Our Ref: TS/DAN/E4736/17675

26th May 2020

Arun District Council
Planning Department
C/O
Dandara Southern

FONTWELL –RESPONSE TO DRAINAGE COMMENTS

FON-182-02-A

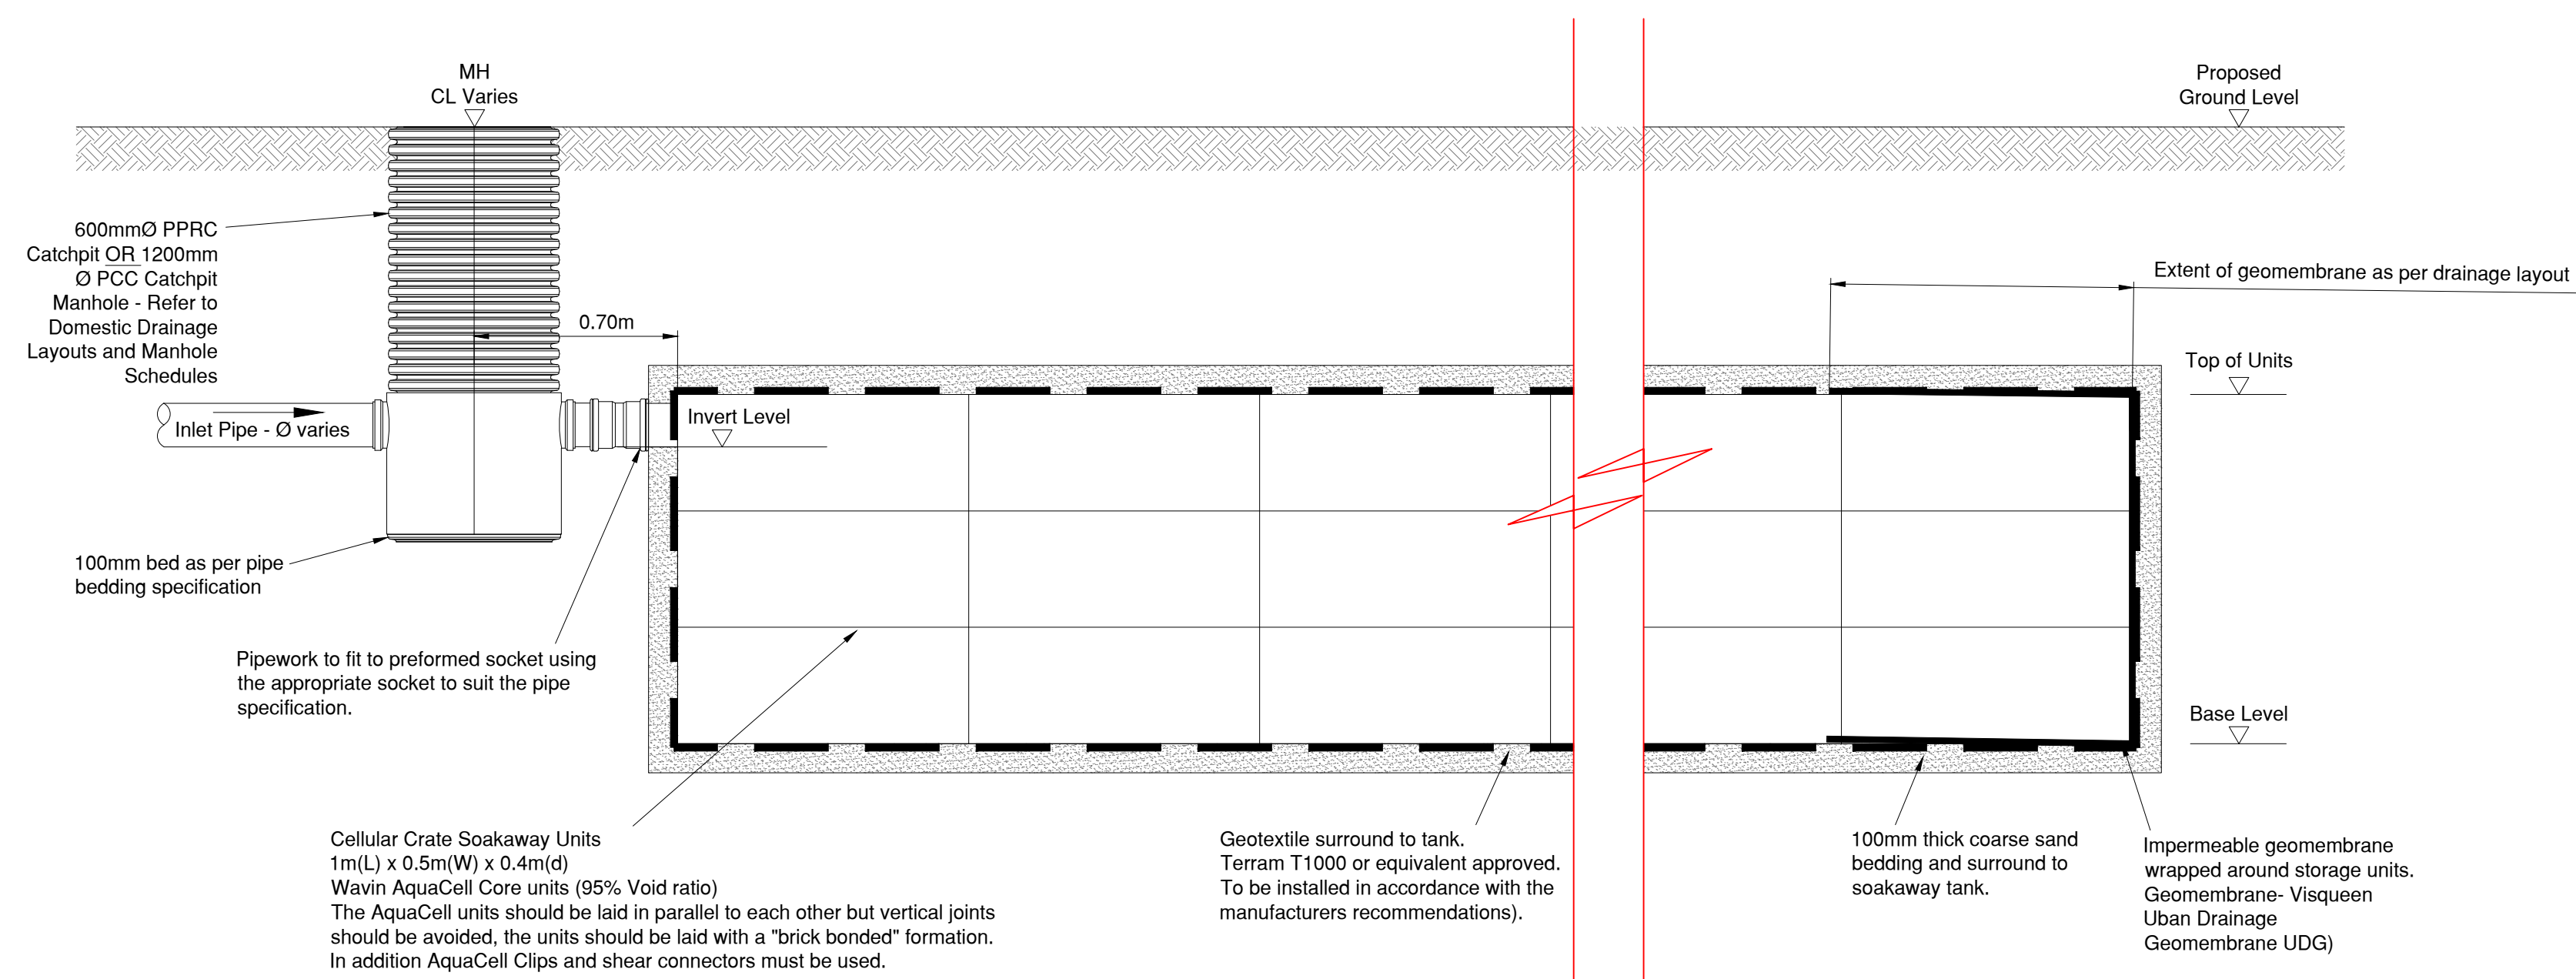
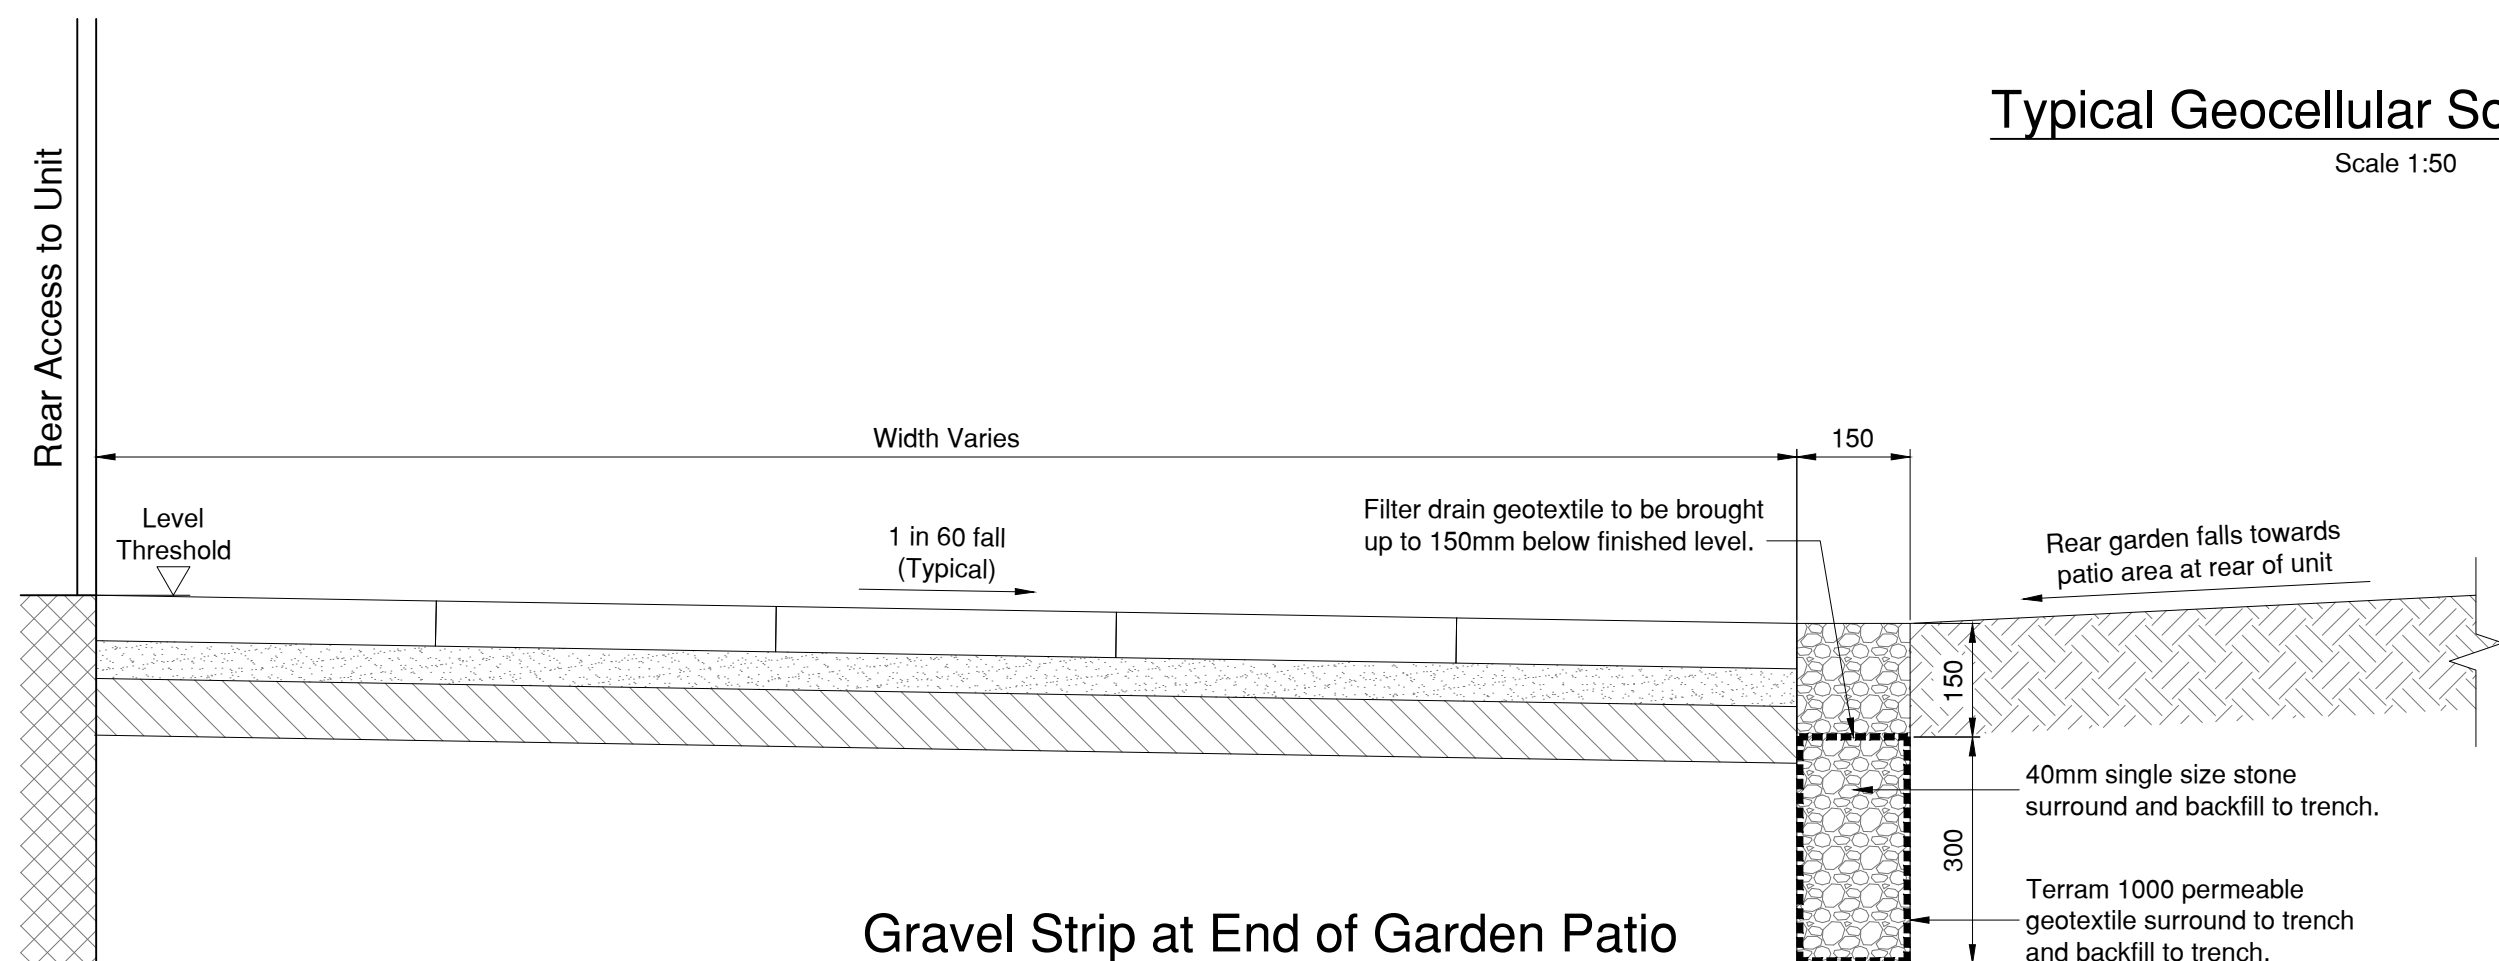
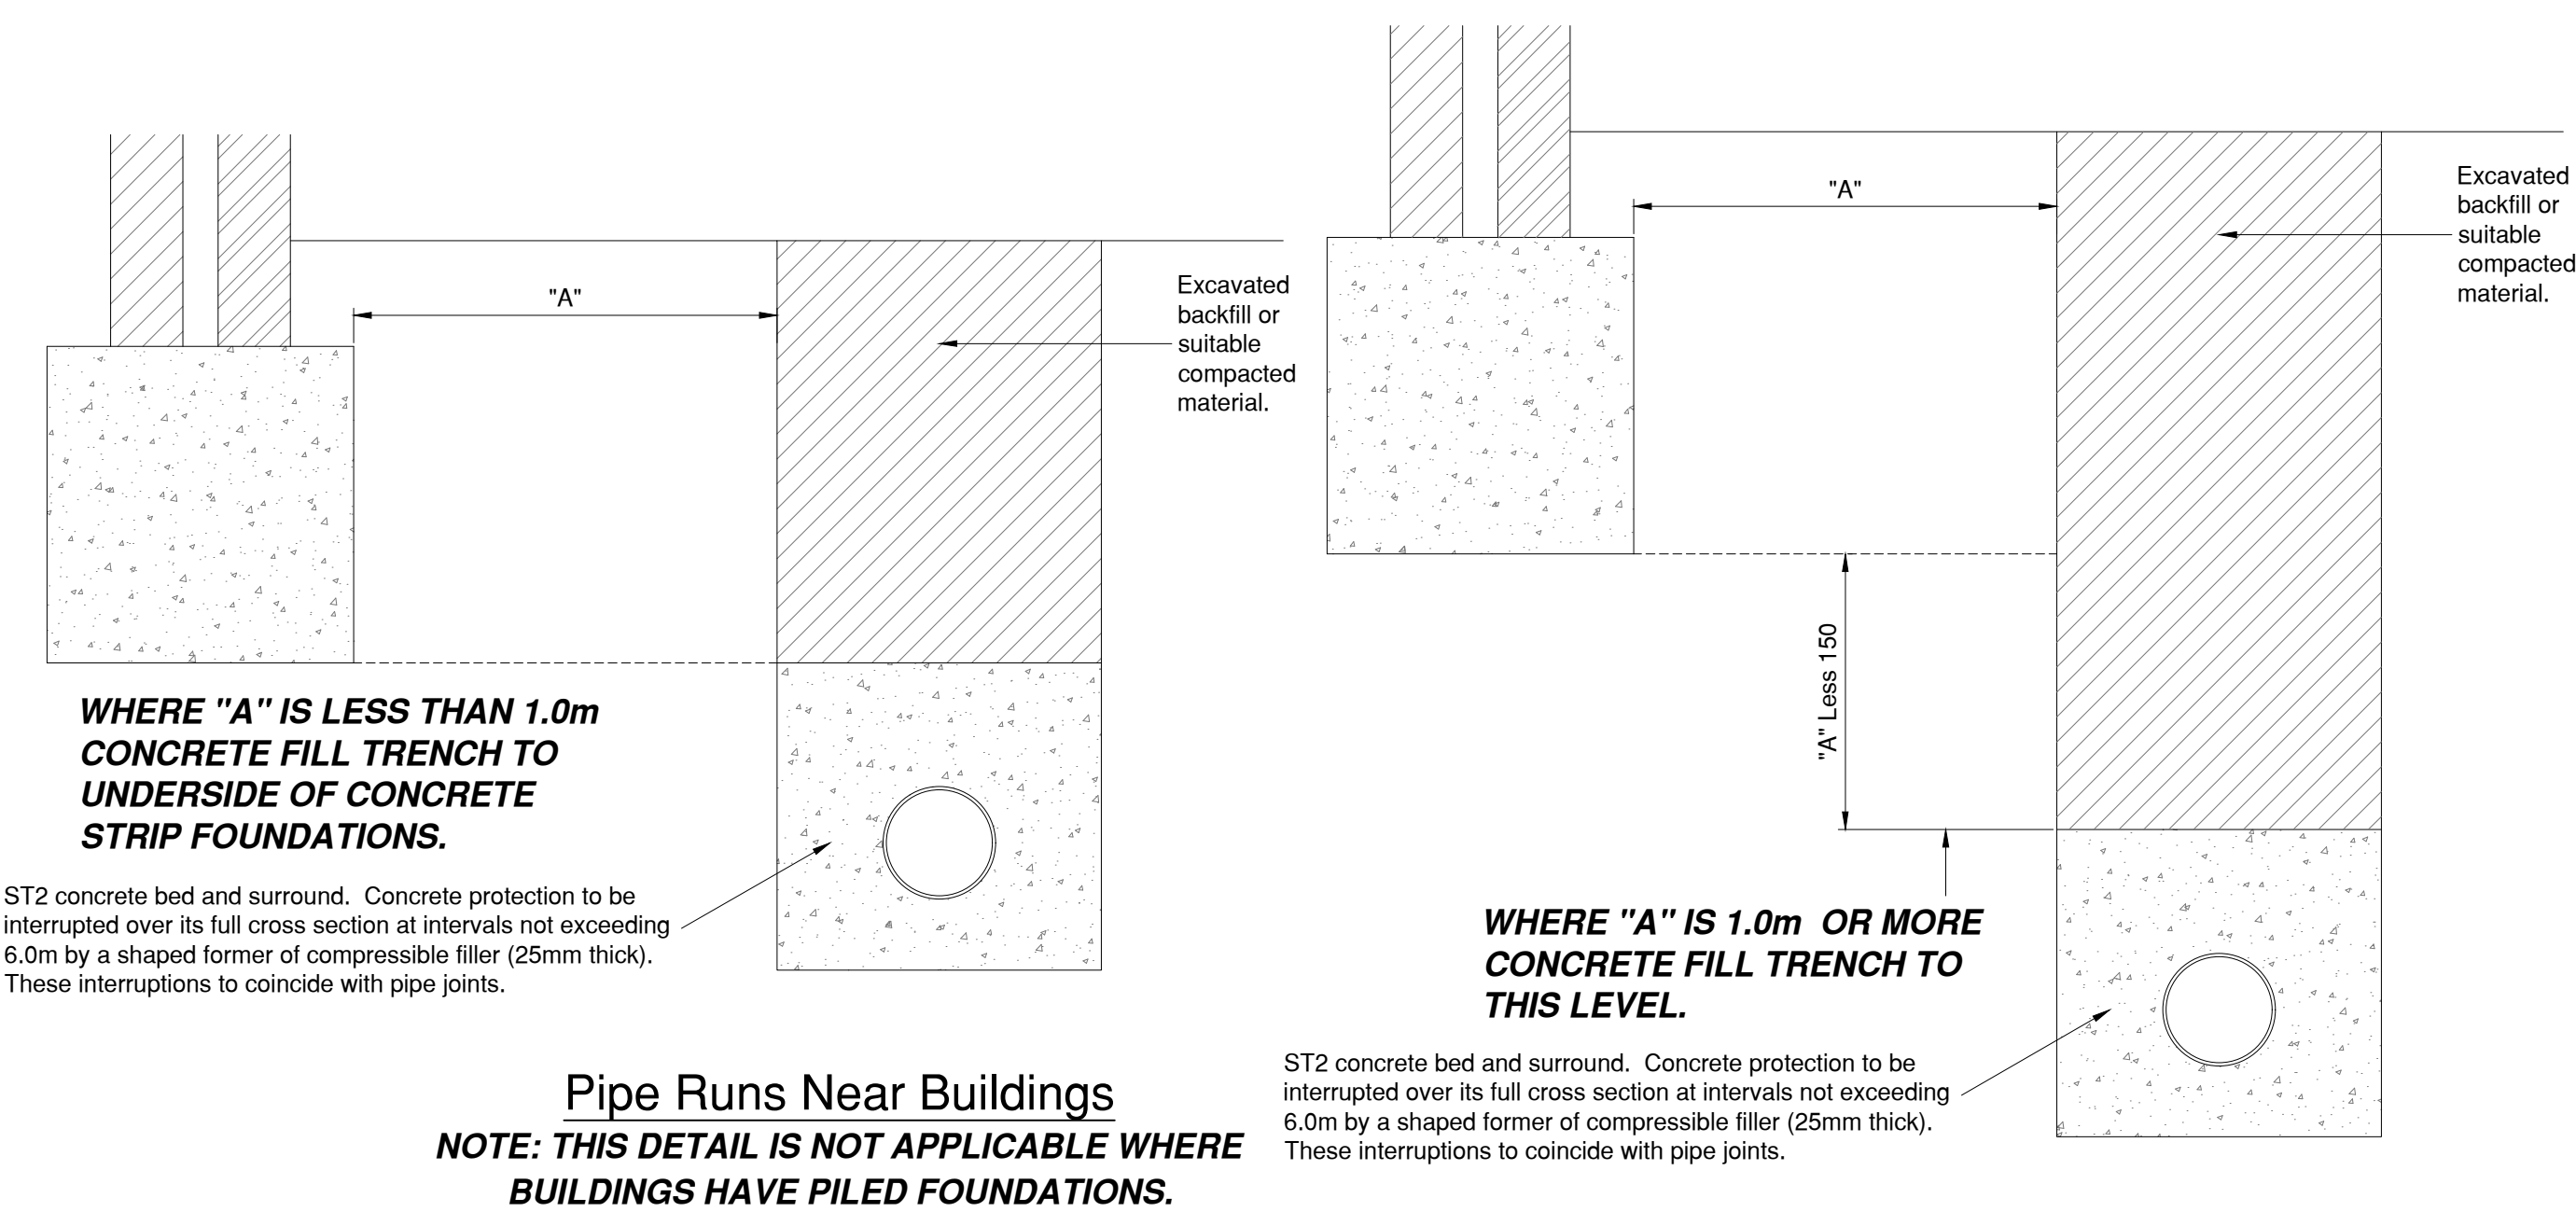
6. *Fully detailed construction drawings ...* - This information is included in the updated detailed pack which contains construction details as well
7. *...the geocellular crates to receive an impermeable liner wrapping...* - This detail only interfaces with soakaways comprising of geocellular crates as well. A typical construction detail of this arrangement has been included in the construction pack

14. *Granular Soakaway detail...*-This has now been updated and removed as only cellular crate soakaways are proposed.
15. *Hydraulic Calculations....* - These are appended to this letter and include the area falling in the infiltration basin as well as a surcharge outfall to simulate the soakaway peak water level. The orifice is part of a future phase within the eastern part of the development and is to restrict flows from that part of the development when it comes forward. It does not impact the current phase 1. The area of the infiltration basin has been included as part of the contributing impermeable areas

Drawing No. FON-130-04-D

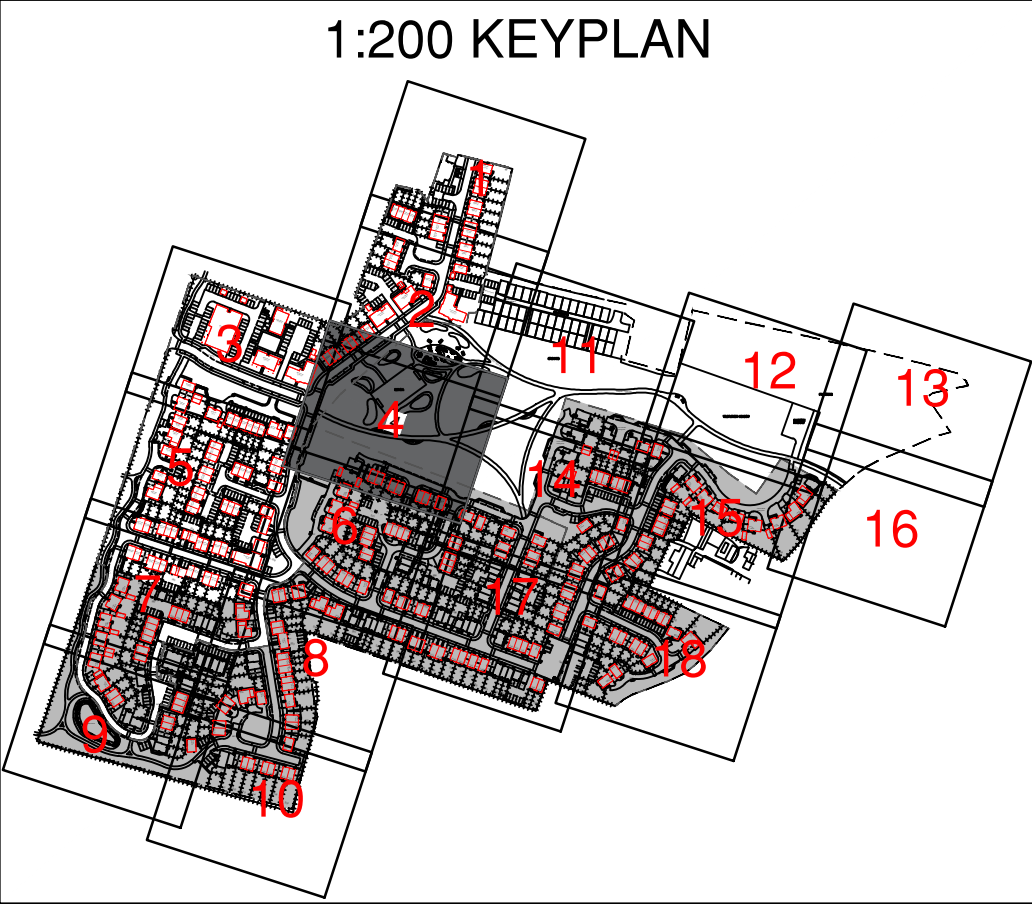
9. *Indicated all pipe inverts, diameters, gradients, soakaway base and inlet levels-* This information is provided on the Domestic Drainage Layout drawings FON-130-01 to 10;
